From: Peter Dixon [REDACTED]
Sent: 11 March 2018 17:44
To: Planning
Cc: Anita Gardner
Subject: Planning at 93 Middleton Road M/133/17/PL

**Demolition & erection of 1 No. dwelling to
existing ground floor slab - REVISED PLANS**

**Little Thatch, 93 Middleton Road, Middleton on
Sea PO22 6DW**

BLOCK AND SITE PLAN

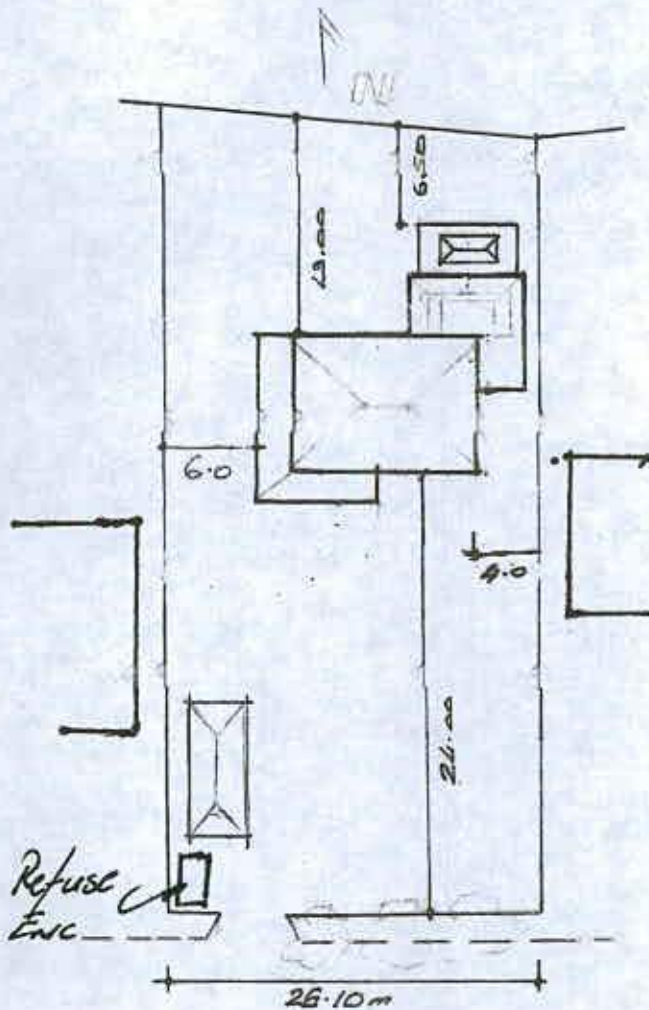
We also still have concerns about the presentation
and accuracy of the plans. Furthermore, our
property has not been added to the 1:500 Block
Plan. The Location Plan is out of date/incorrect.
Our house is not drawn to scale and is much closer
to the boundary in reality. We feel that the current
and proposed relationship with our house needs to
be included in the revised set of plans. The various
distances to the mutual boundary are not the only
issues that need to be assessed and they cannot
be looked at in isolation. We question the 1m gap
annotated on the plan. The block plan also shows
the boundary to house gap as 3.3m. Whereas AB-
100-7 V5 – 'proposed floor plan and elevation'
shows this distance to be 3.4m. We would therefore
like to request please that key boundary

EAST ELEVATION

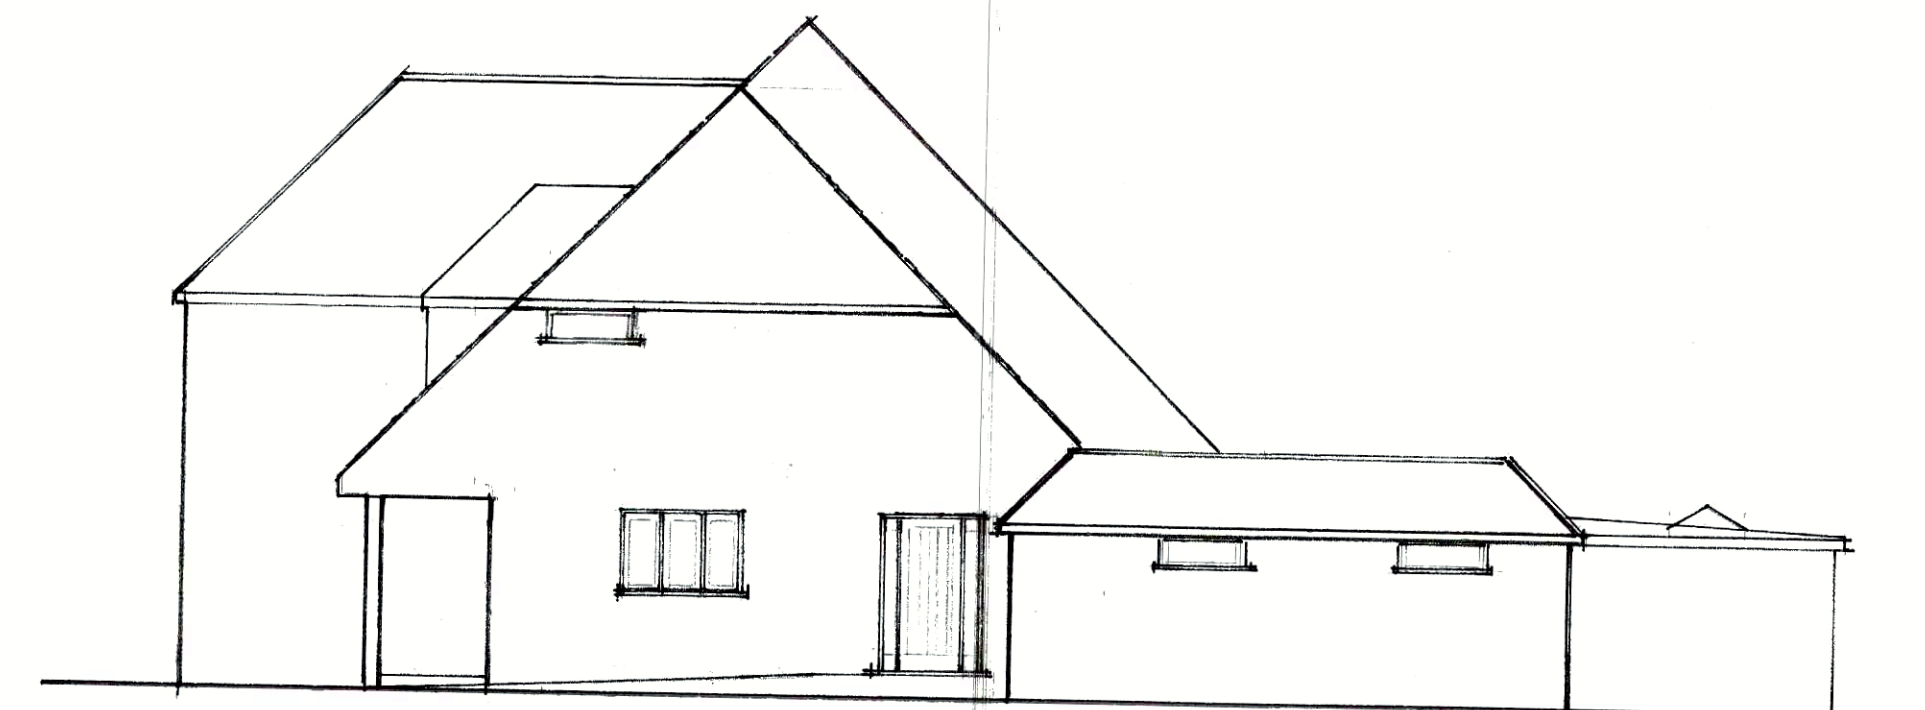
Due to the proposed arrangement we don't consider this door to be a 'rear entrance' as annotated. It would be well-used by the occupiers of the annexe / self-contained unit and would be the equivalent of 'front door' with all its associated footfall, activity and lighting etc. Its relocation to a different elevation does not 'move the rear entrance door further from the east boundary' (email from Mr Wilson to Planners 8/2/18) and raises new issues for us - the ramp shown on the plans increases its overall height and the direction of the lighting is likely to be more disturbing.

Whilst it is high level, its installation 1.7m from the finished floor level would still allow certain people, depending on their height, to look out of it towards our sitting out area and our kitchen diner (with rooflights) and dormers above - these all face no. 93 and are within close proximity of the boundary. 1.7m is shorter than 5' 6" - the average male in England is 5' 9". There would certainly be a perception of being constantly overlooked.

Of particular concern - we would point out that the location of this upper level window on the first floor plan does not tie up with the location shown on the east elevation drawing. The distance between the window in the dormer and the southern frame of the high level window do not seem to correspond.

FIRST FLOOR PLAN.

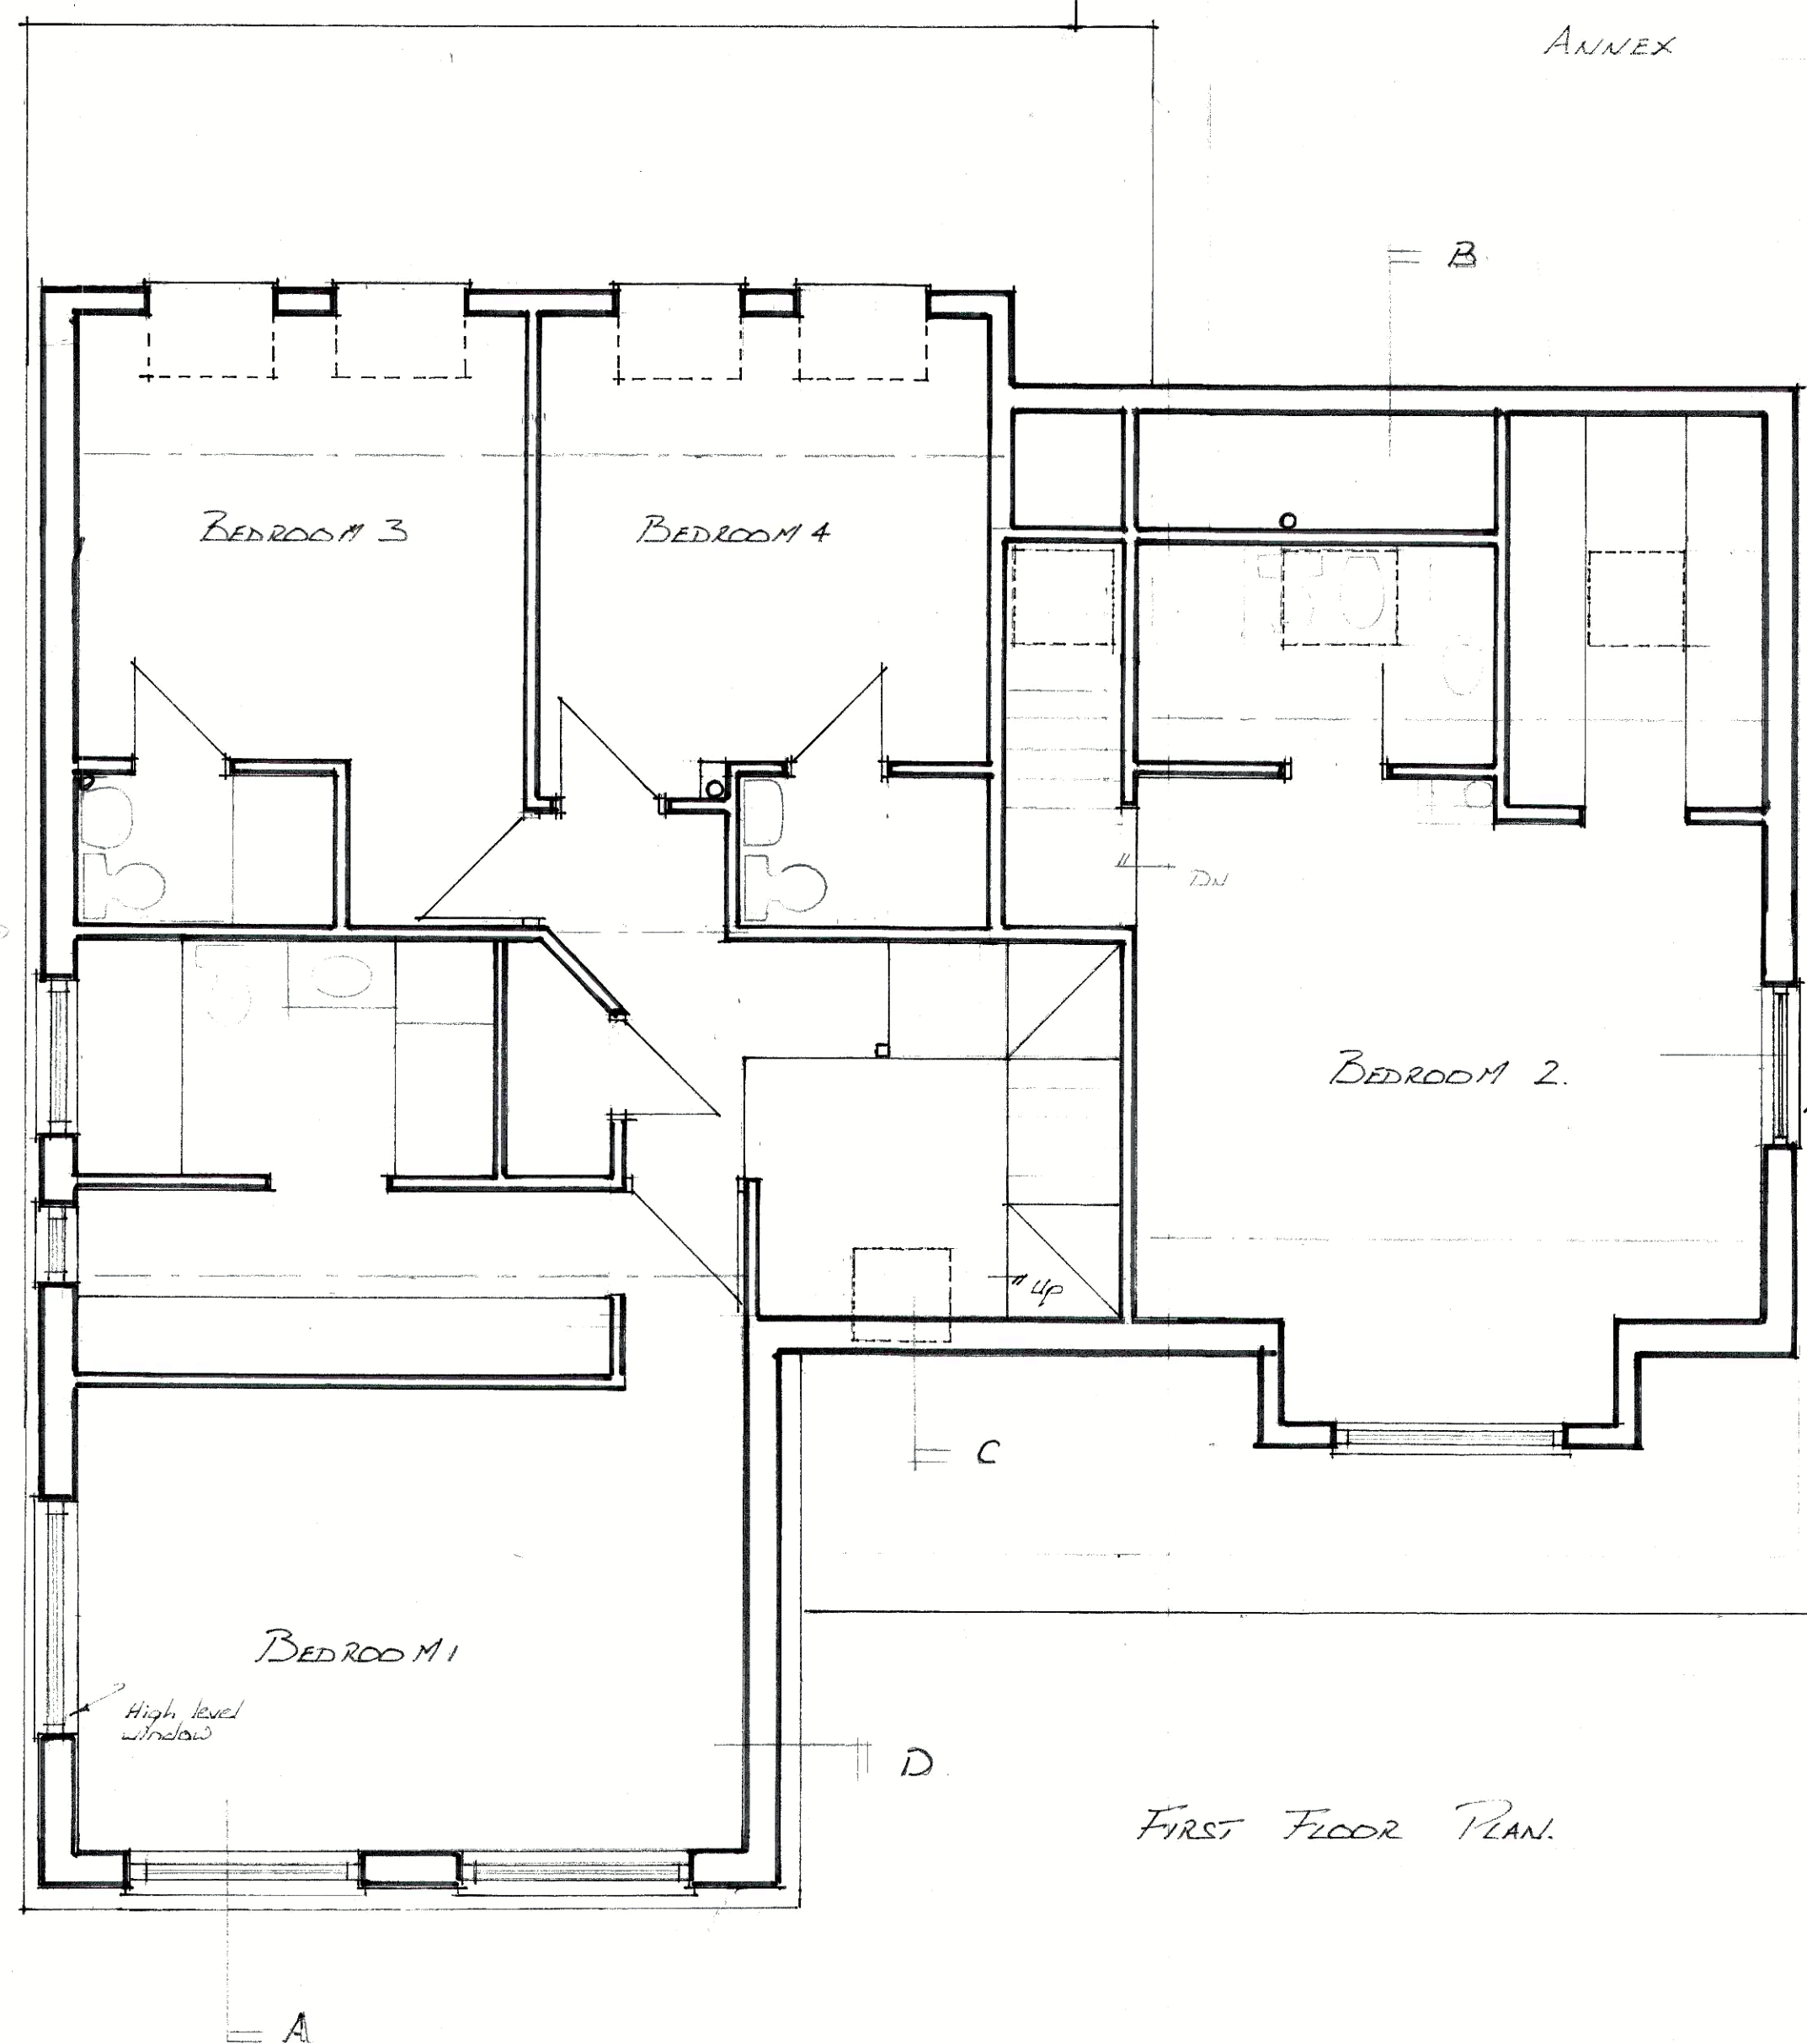
Currently there are only ground floor windows facing us at no. 93, hidden behind the fence. The removal of the two side rooflights is welcomed but we remain concerned about the upper floor window. This would serve the bedroom in the annexe (which is not at all connected with the other bedrooms / first floor).

DRC N°: AB: 100 12

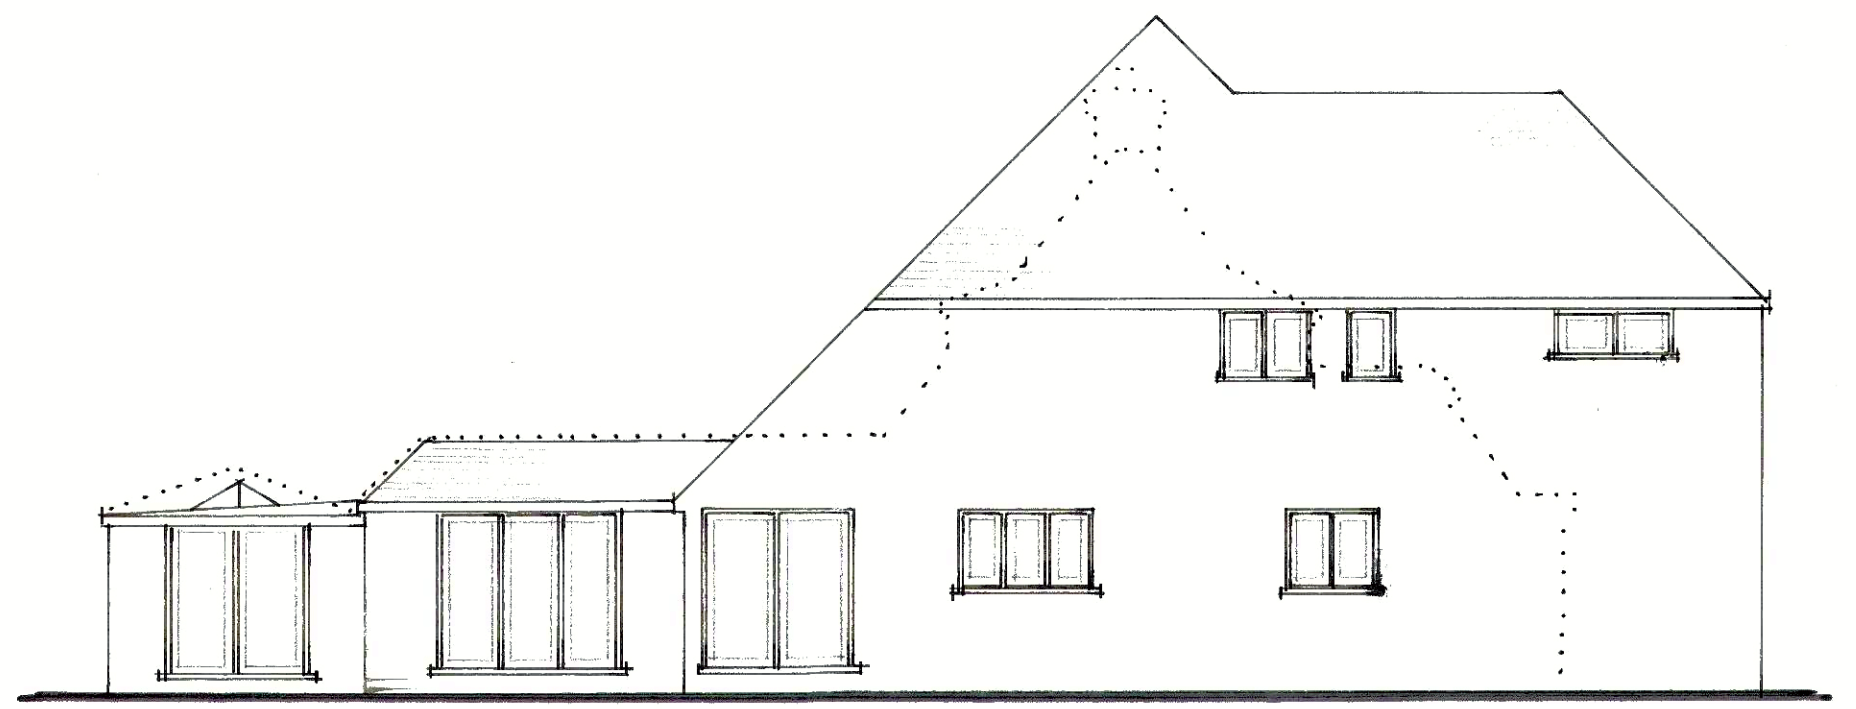
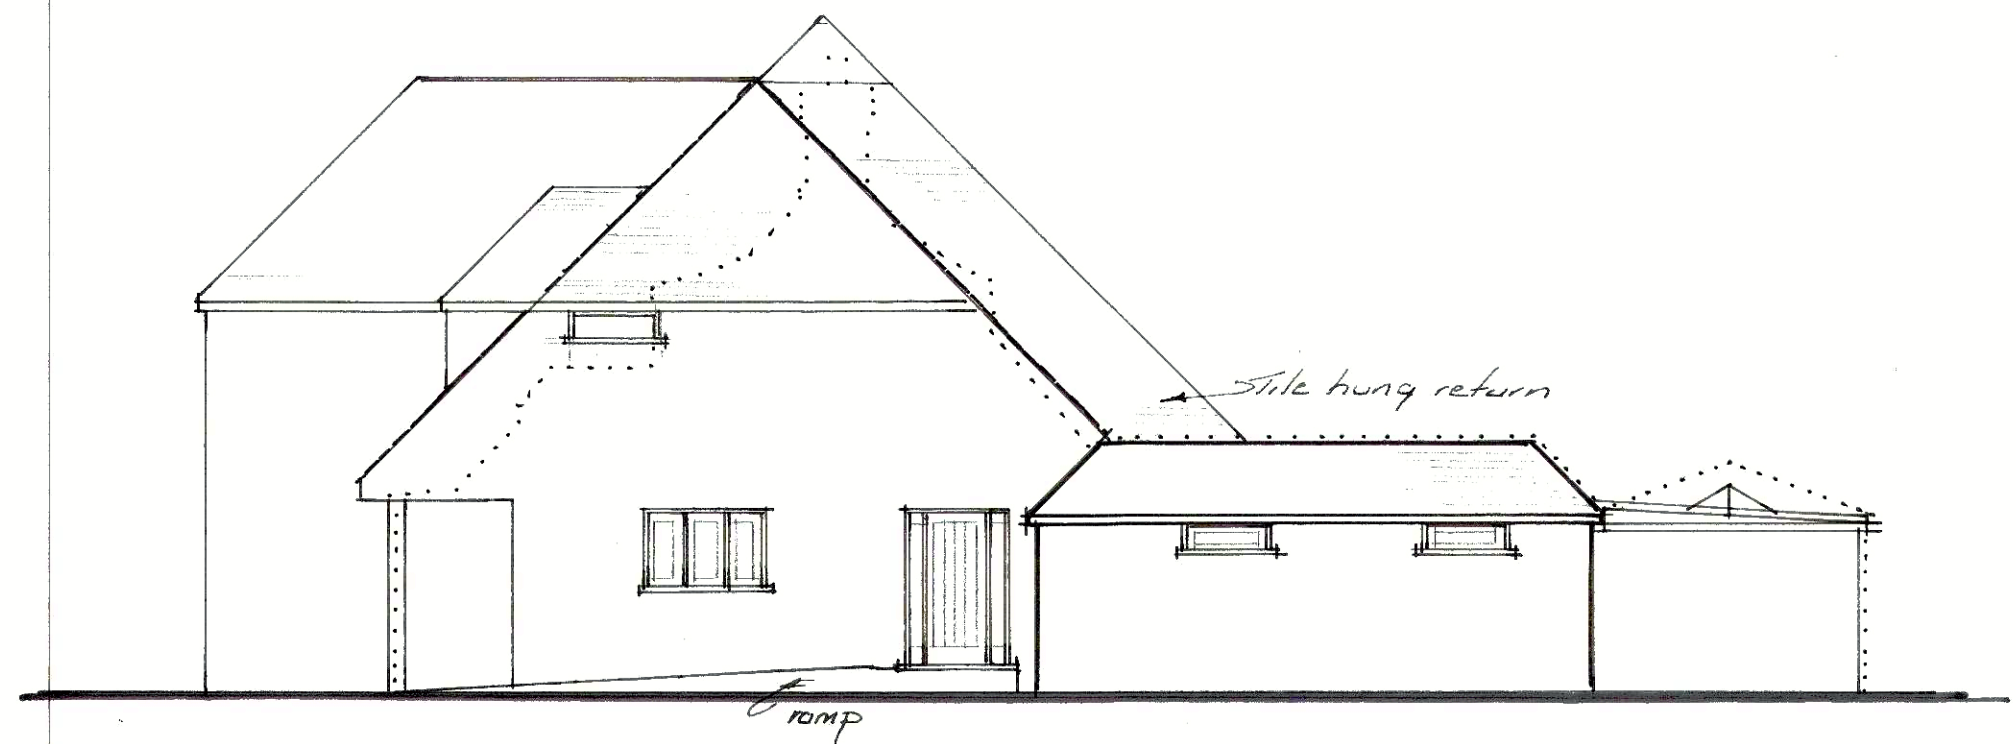
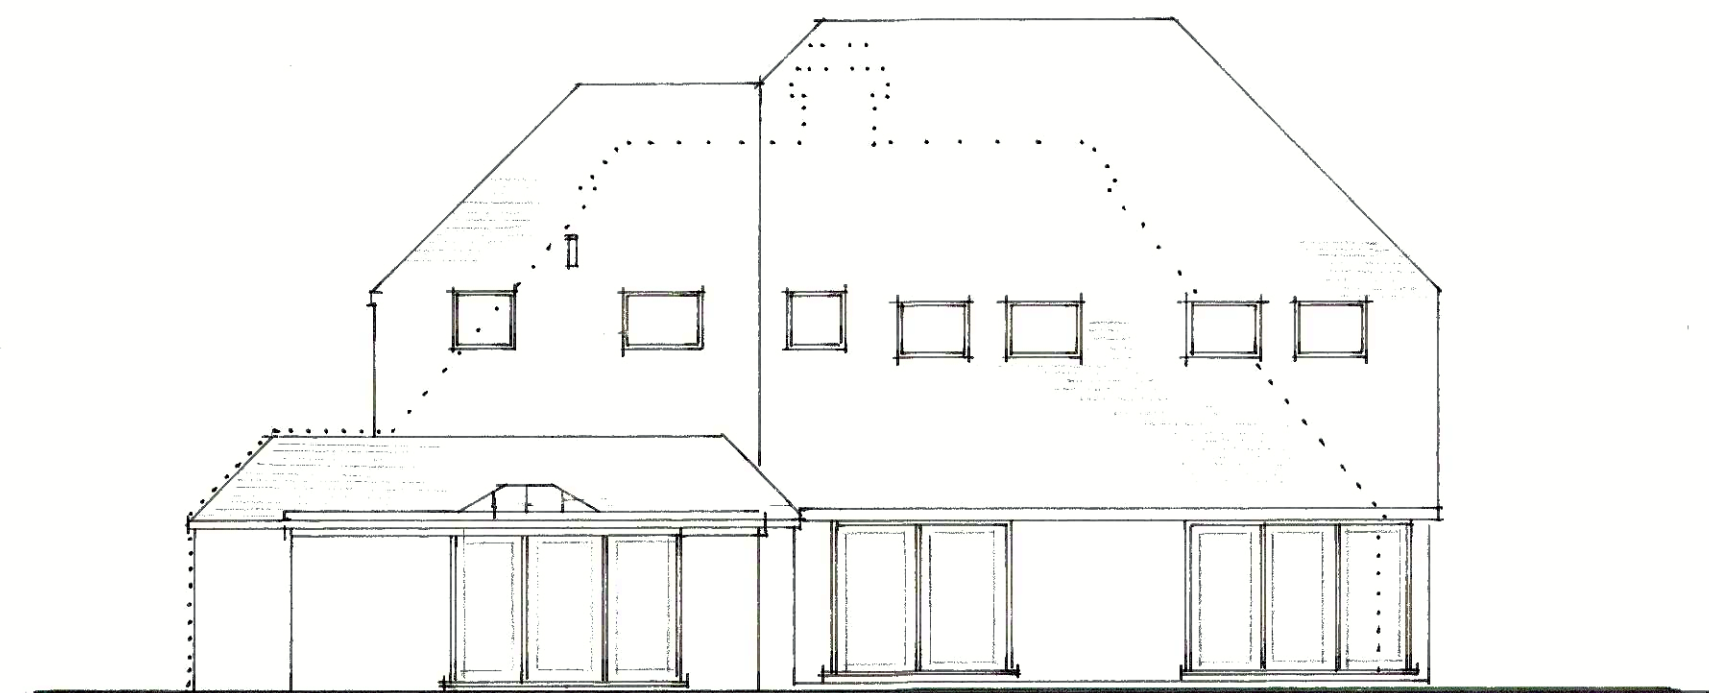
The lowering of the ridge next to us is rather 'token' in nature and, as shown on the comparison drawing (no. AB:100 12), it would still much higher than the existing thatched roof. It is not possible to say if this roof design is lower than the initial Application or whether the main part of the house is now substantially larger than previous Applications appearing to make it lower. The substantial increase in the height would be particularly dominating from our point of view but the overall bulk of the roof would be prominent from various angles. The size of the new front dormer (with wide front cheeks) and the over-reliance on rooflights on the rear elevation, in particular, emphasises its scale. A more subservient annexe would help minimise the impact on the eastern side.

These revised plans add additional bulk at the front of the dwelling, more or less in line with the rooflights over our kitchen diner and the dormers above. This element raises a new issue for us and the east elevation on the comparison drawing helps to highlight the extra massing when viewed from our property.

It isn't clear how far the east elevation will be extended on its south side. The measurements are unclear. Currently there is a large, flat roof, glass extension to the lounge similar to a conservatory. If this is now to be incorporated in the southern roof line then the drawings are not to scale as this flat roof extends roughly 2m and does not appear to be shown on the dotted line on plan AB-100-12 V5.
